From: Sarah Burrow <Sarah.Burrow@arun.gov.uk>
Sent: 15 July 2021 15:49
To: Planning.Responses <Planning.Responses@arun.gov.uk>
Cc: Anita Gardner <Anita.Gardner@arun.gov.uk>
Subject: RE: Planning Consultation on: EP/69/21/PL

Engineers Comments Regarding Surface Water Drainage

Application No: EP/69/21/PL
Registered: 14th June 2021
Site Address: 4 Beechlands Close and land east of 18 Montpelier Road East Preston BN16 1JZ
Grid Reference: 507266 102379
Description of Works: 1 No. 3-bed bungalow (resubmission following EP/10/21/PL). This site is in CIL Zone 4 & is CIL Liable as new dwelling.

SITE PLAN

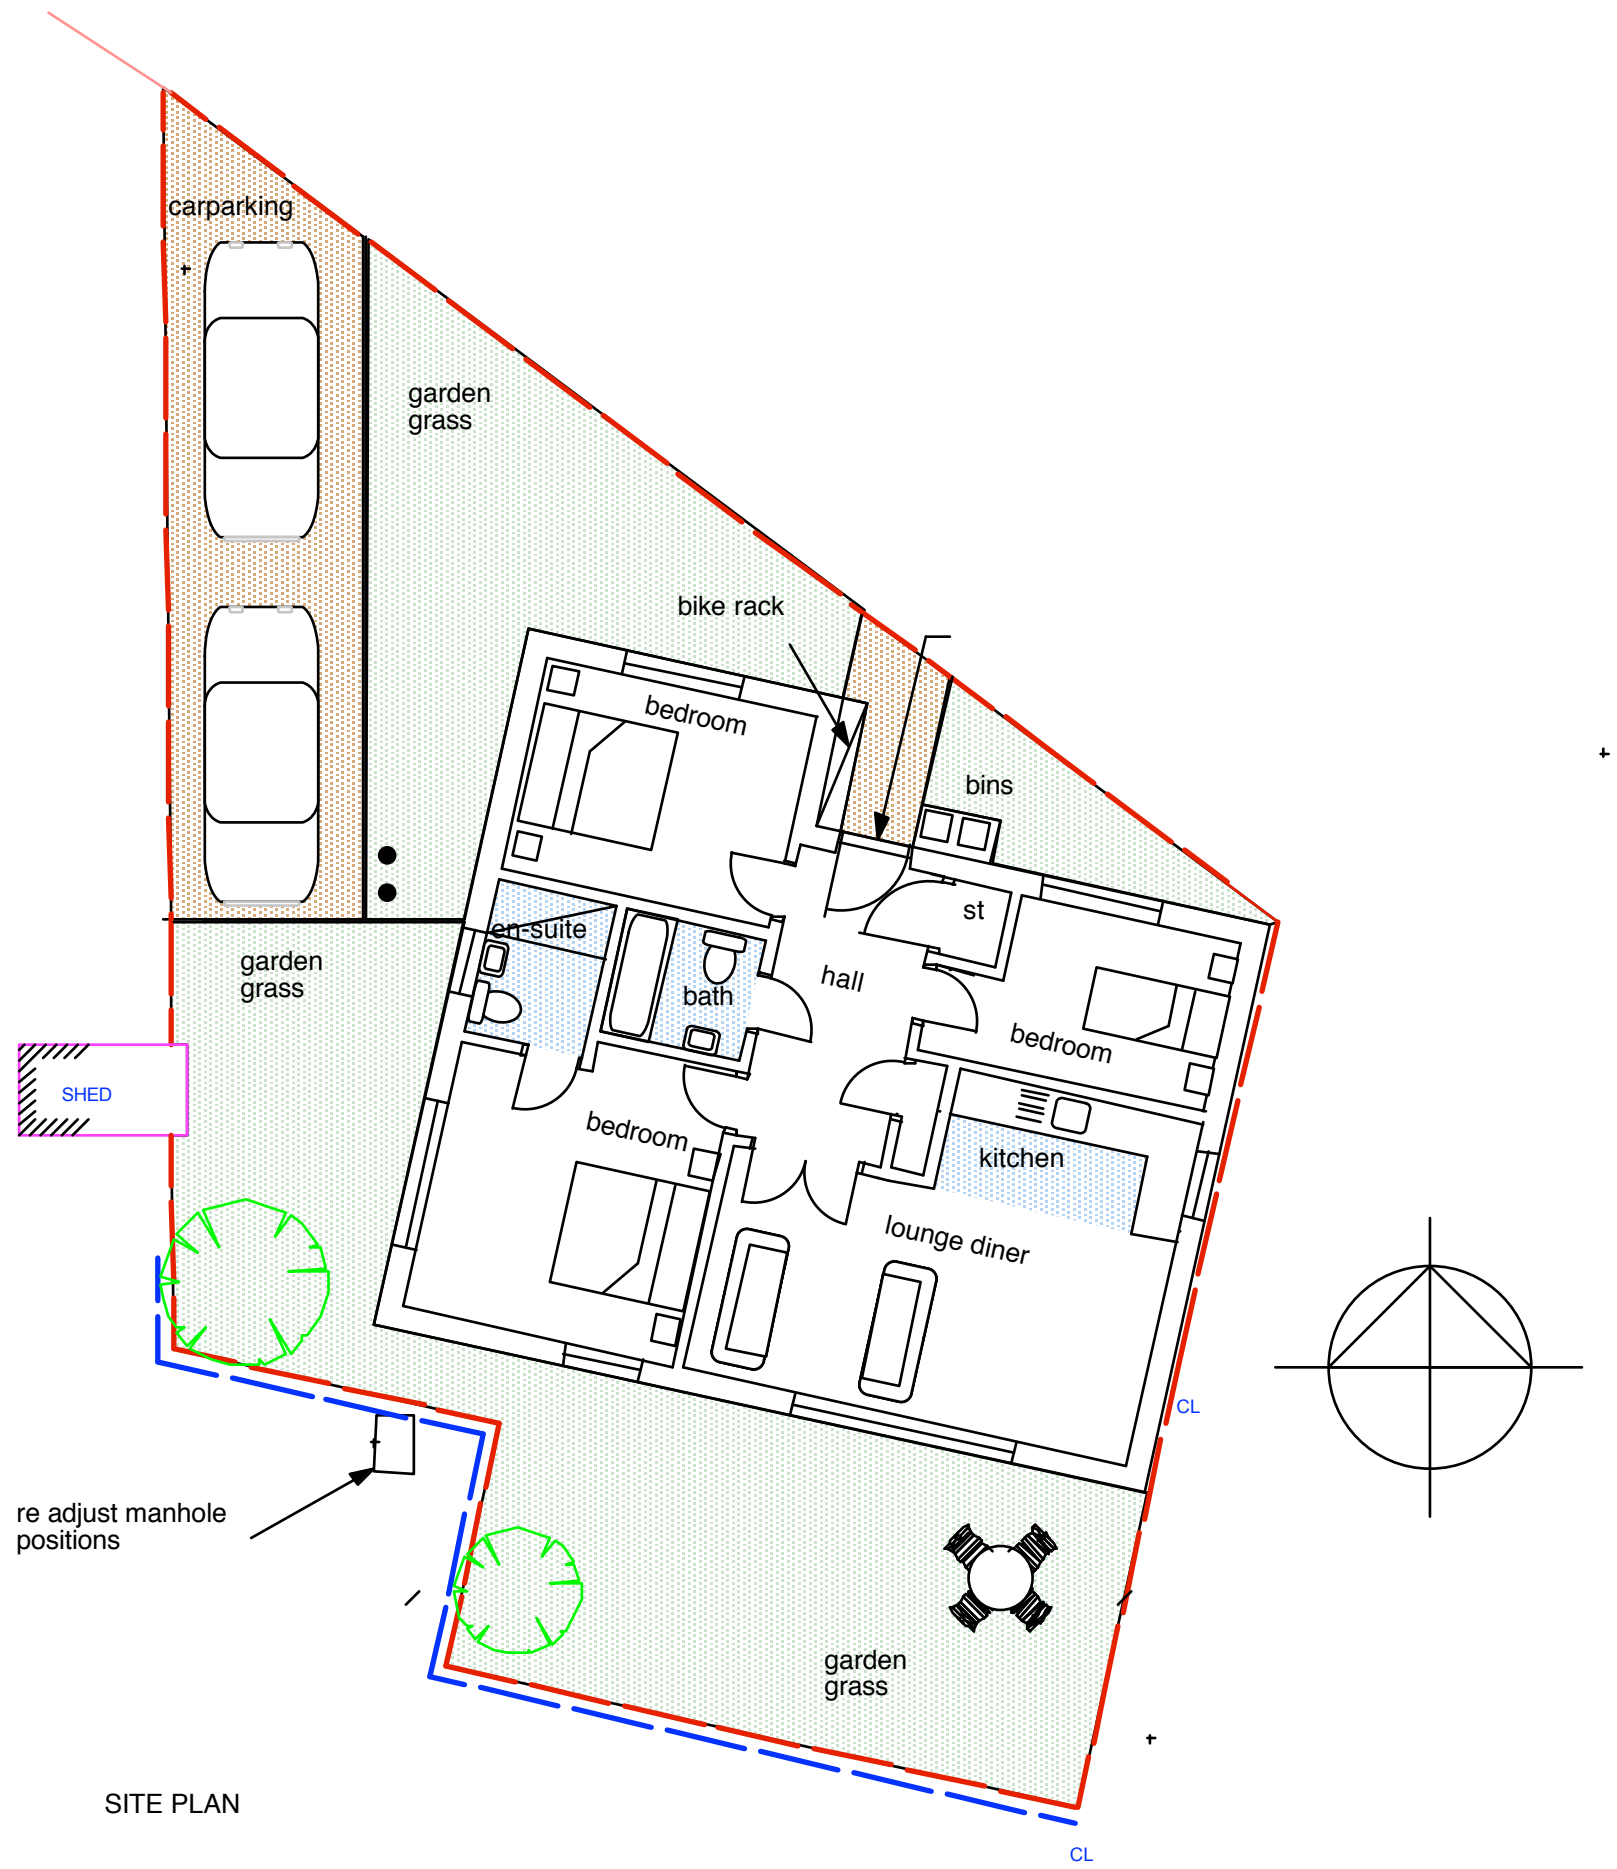
There is inadequate garden space provided on site to be able to utilise infiltration as a means of surface water drainage within the red line boundary. (Building Regulations state that soakaways must be located a minimum of 5m from any buildings.)

Not utilising infiltration due to lack of space is inappropriate, this proposal unduly prejudices drainage design and is likely to not allow for the hierarchy for sustainable drainage to be followed. *There are no ordinary watercourses within or adjacent to the site, if infiltration is unviable due to inadequate space the water would have to go to foul sewer, it is unlikely this would be acceptable to Southern Water.*
